ADDENDUM NO. 2

Date: April 7, 2017

Project: Hall Elementary School
Portland Public Schools/City of Portland
Portland, Maine

2 MASONRY HEAD DETAIL - TYPE 1F
AE601, AE602 AE603 SCALE: 1 1/2" = 1'-0"

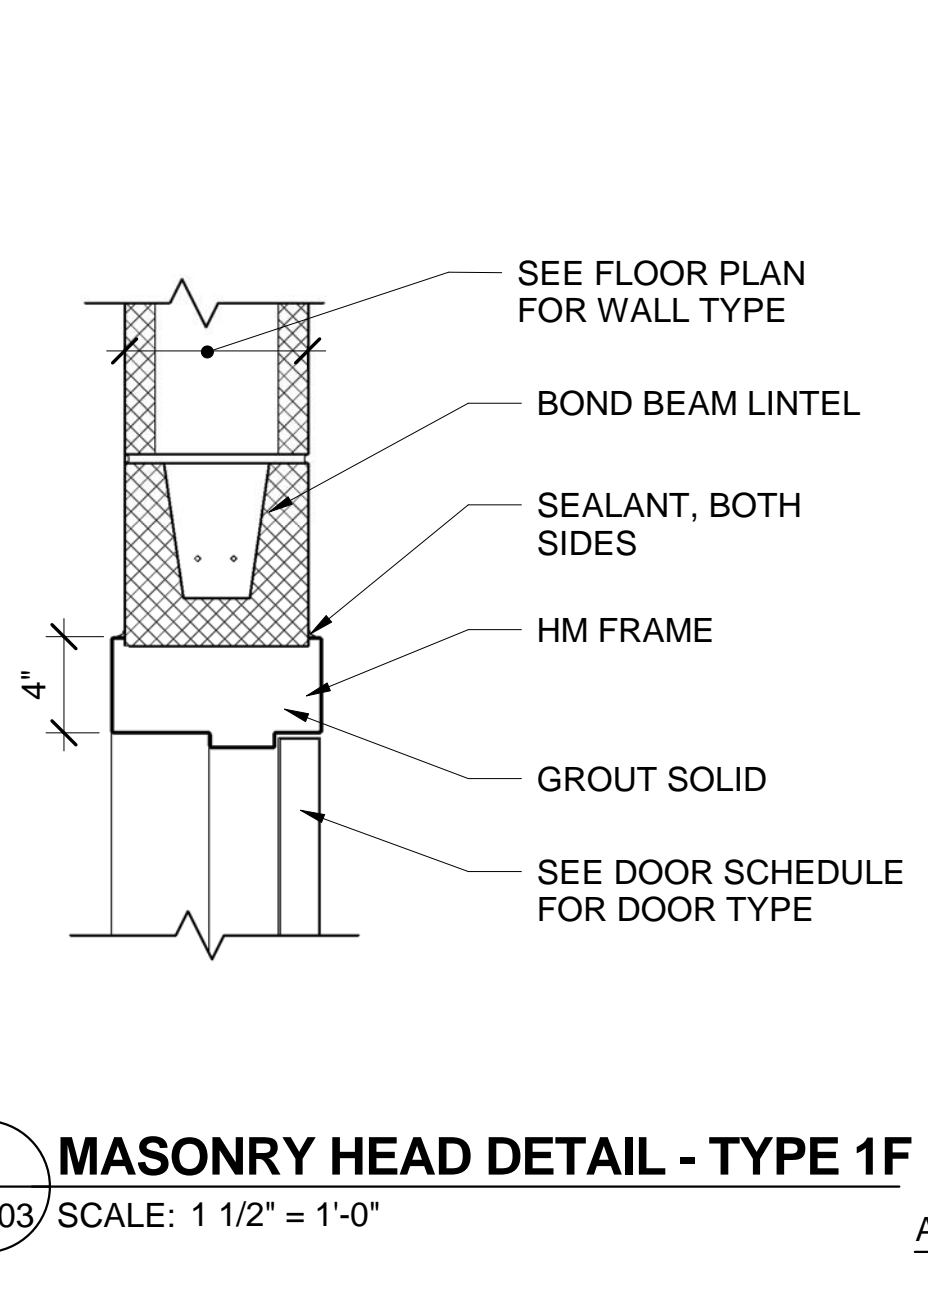
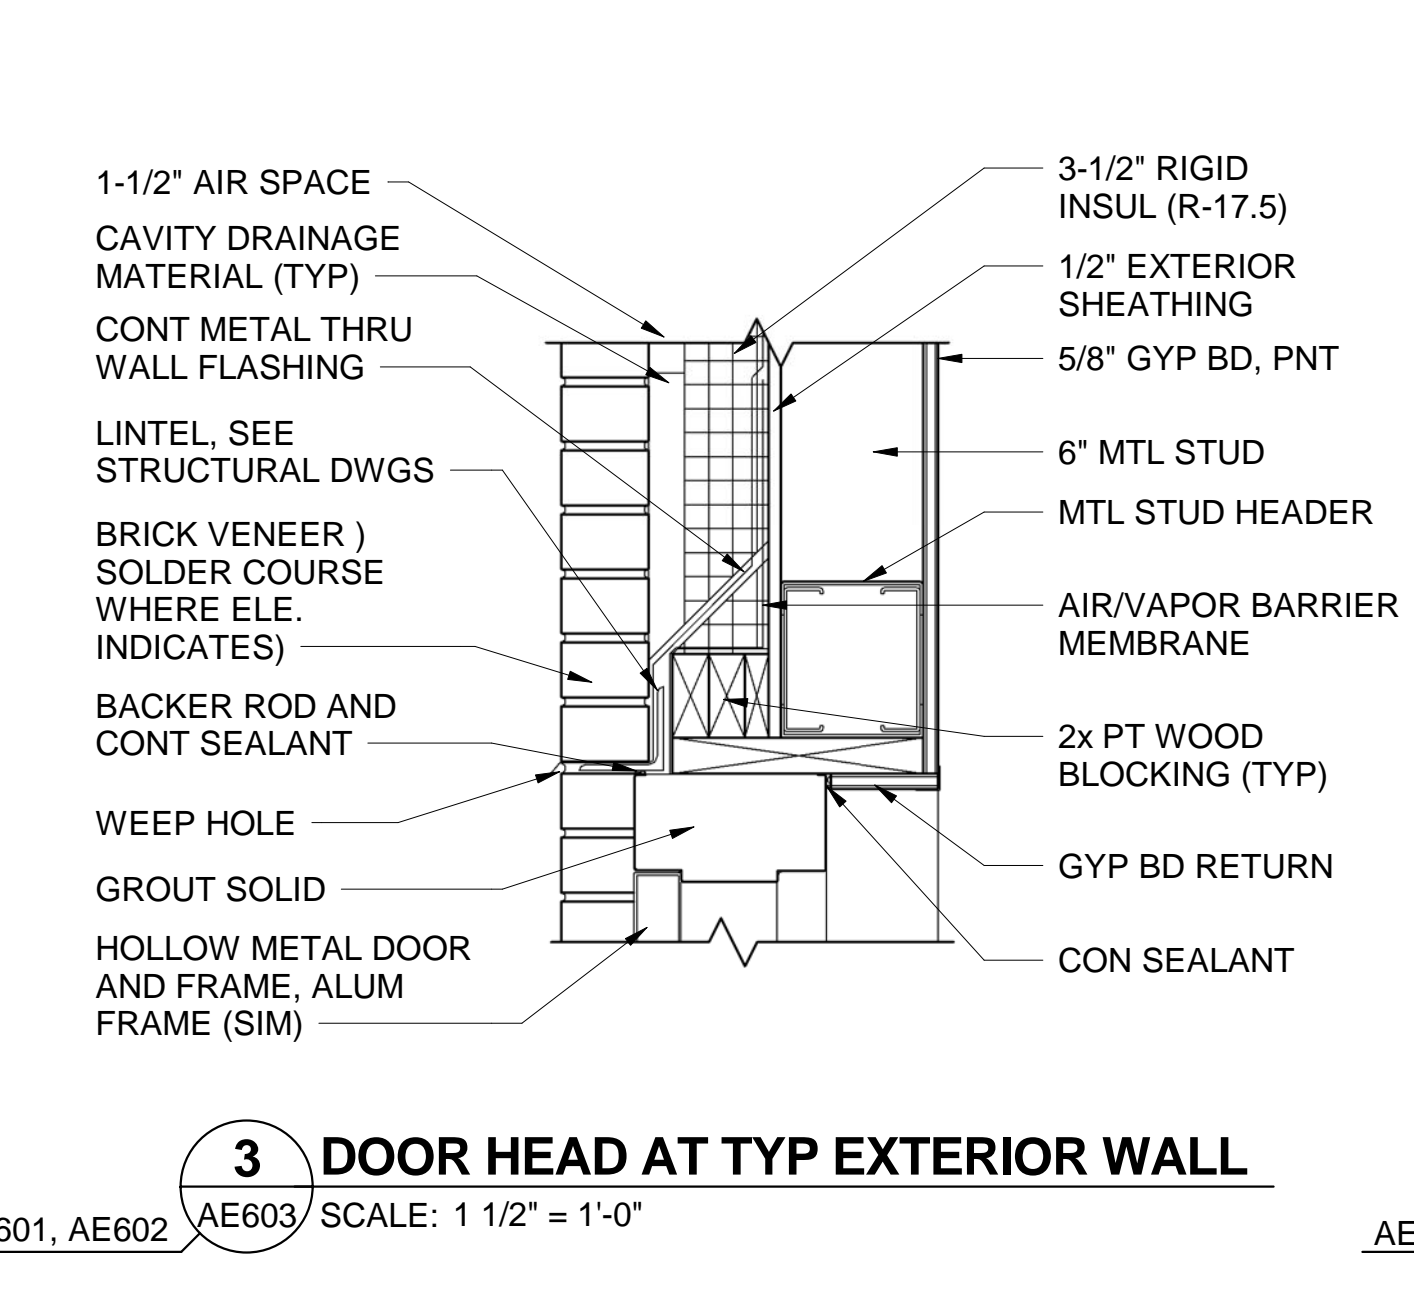
1. Wall type 1F will require a UL rated block.
2. Door A20 is also Curtainwall C7.

12 READ B09 - WEST ELEV
AE102/AE741 SCALE: 1/4" = 1'-0"

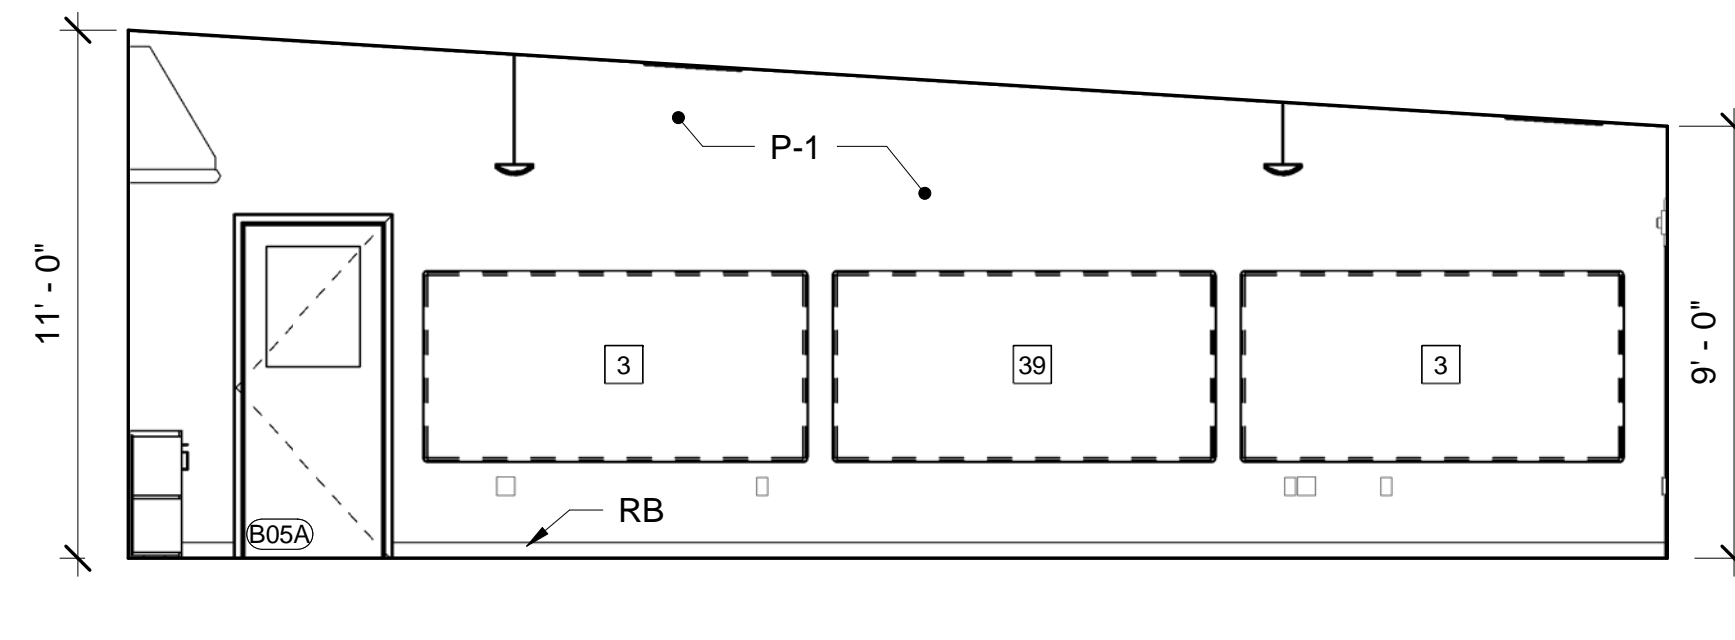
1. Detail 2: Delete the reference to acoustical wall panel.
2. Detail 10: Provide two acoustical wall panels (awp-2) on this wall.

1 2ND GRADE C18 - NORTH ELEV
AE103/AE744 SCALE: 1/4" = 1'-0"

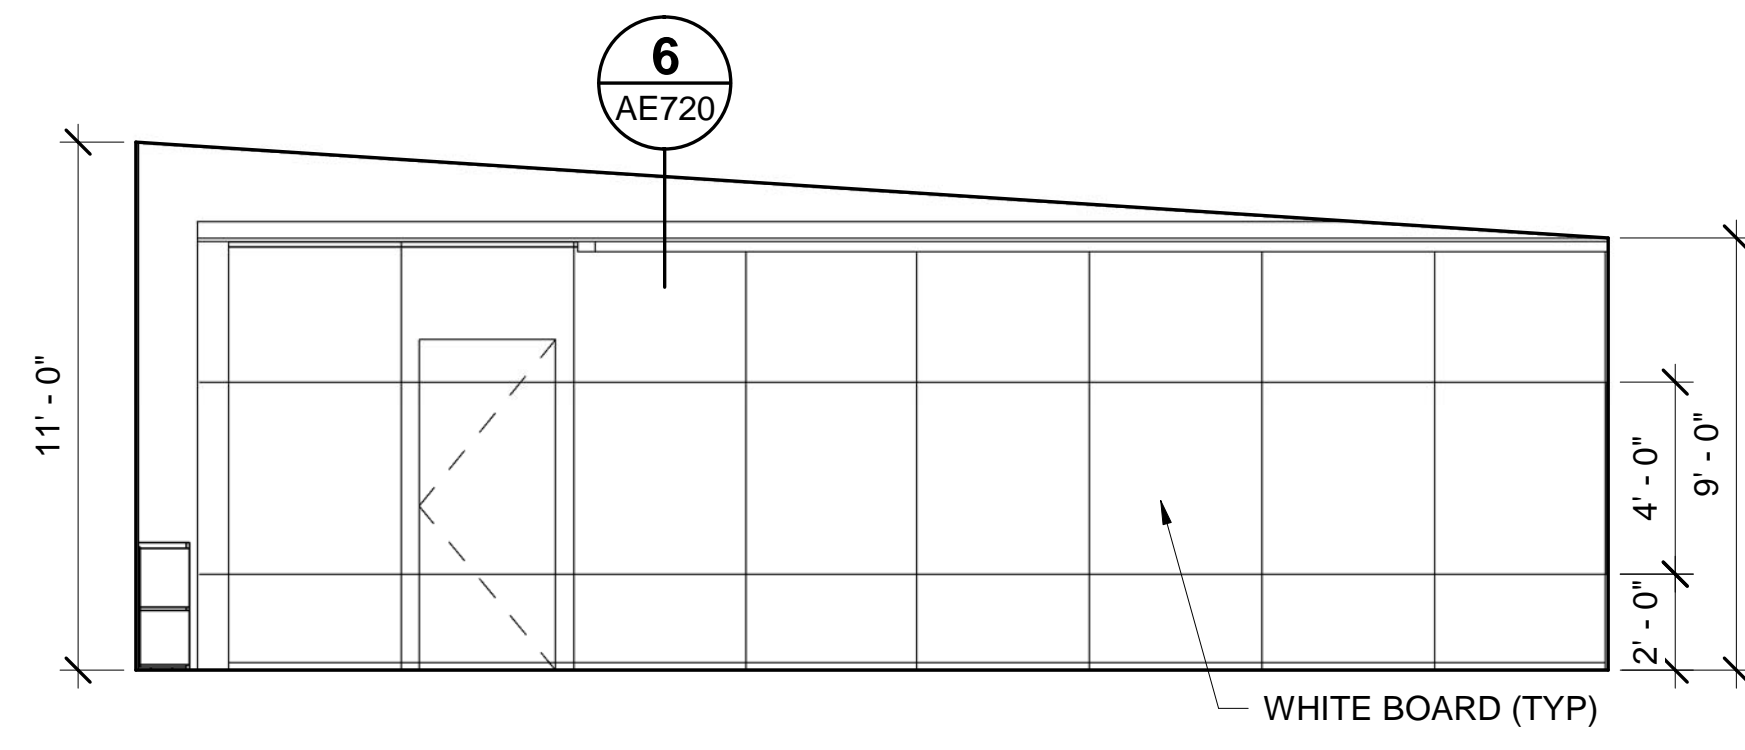
8. Room C19: The finish schedule is correct indicating acoustical wall panels on the North and East walls. These are to be similar to detail 1 and 4 on AE744.

10 2ND GRADE C14 - EAST ELEV
AE103/AE744 SCALE: 1/4" = 1'-0"

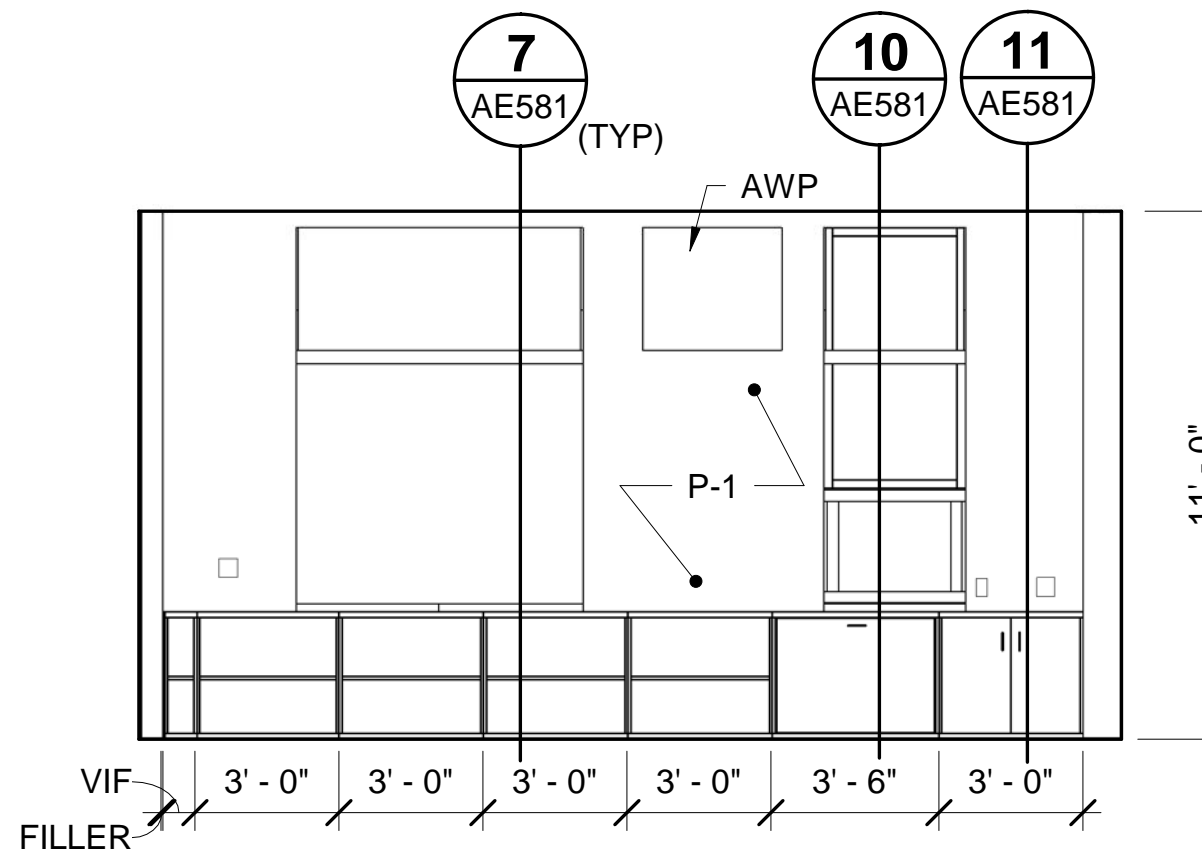
9. Room C22: The finish schedule is correct indicating acoustical wall panels on the North and West walls. These are to be similar to details 11 and 12 on AE744.

14 1ST GRADE C11 - EAST ELEV
AE103/AE744 SCALE: 1/4" = 1'-0"

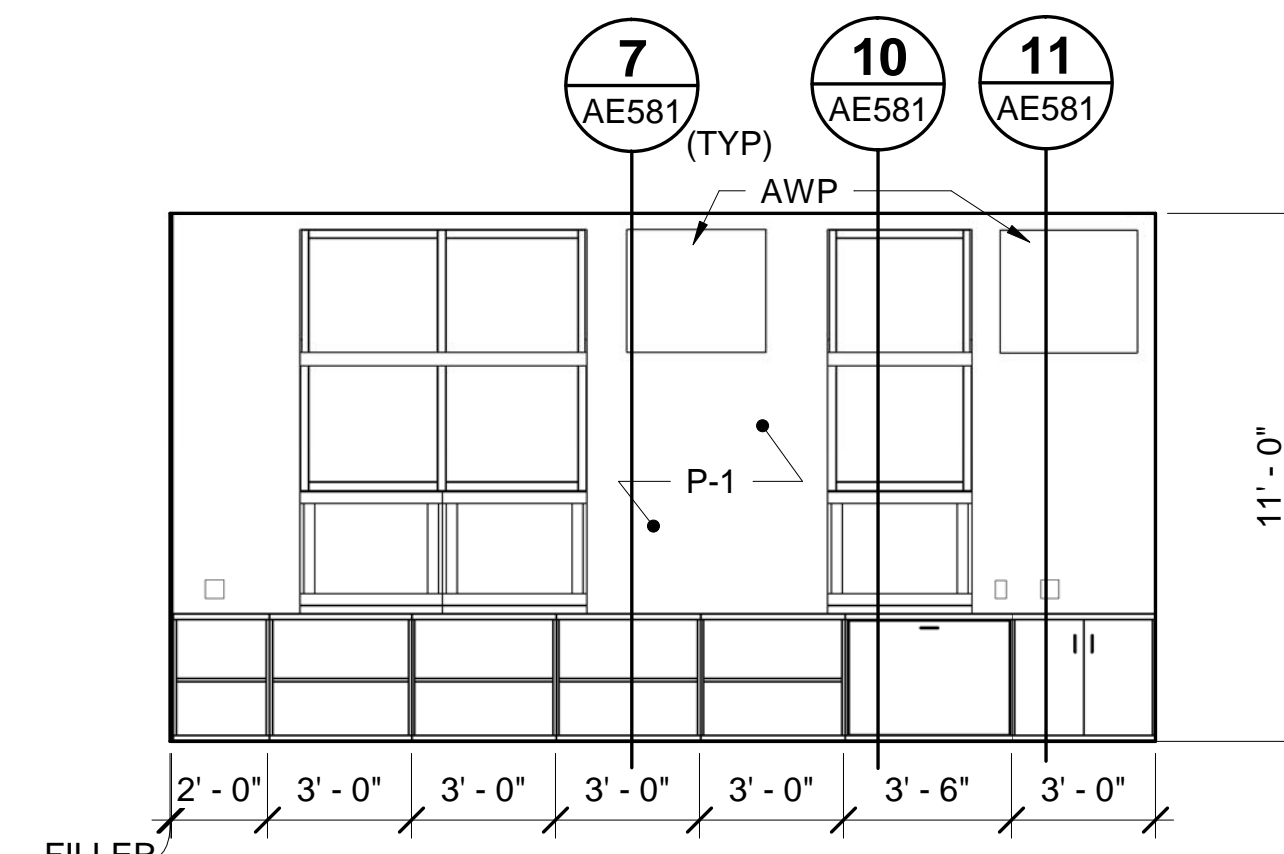
5. Room B09: There are two acoustical wall panels on the East wall.
6. Room C07: There are two acoustical wall panels on the North wall.
7. Room C13: The finish schedule is correct indicating acoustic wall panels on the South and West walls. These are to be similar to details 14 and 15 on AE744.
